Current Zoning: N1-B (Neighborhood 1-B)  
Proposed Zoning: N1-F(CD) (Neighborhood 1-F, conditional)

Approximately 1.99 acres located along the north side of Tom Hunter Road, west of Hidden Forest Drive, and south of I-85.

The petition proposes to allow a multi-dwelling development on a parcel currently developed with one single family detached home.

REZONING SITE PLAN

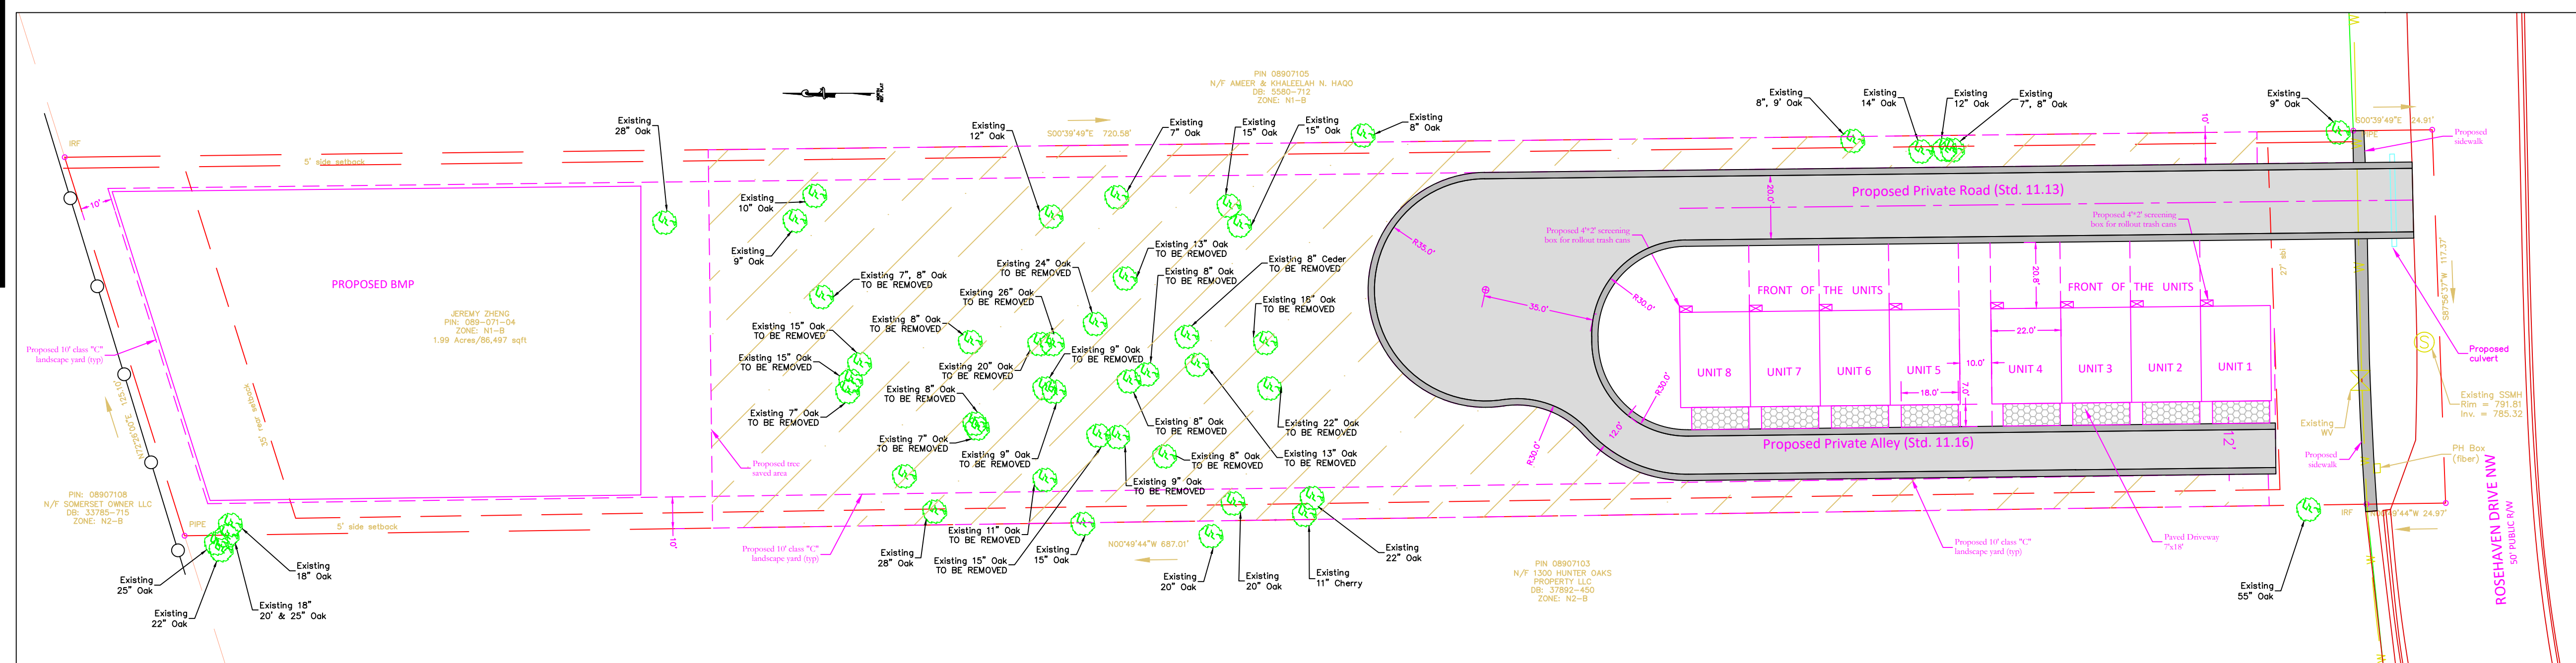
12. Update the ROW dimension label on the site plan to 24' from the back of sidewalk.
-
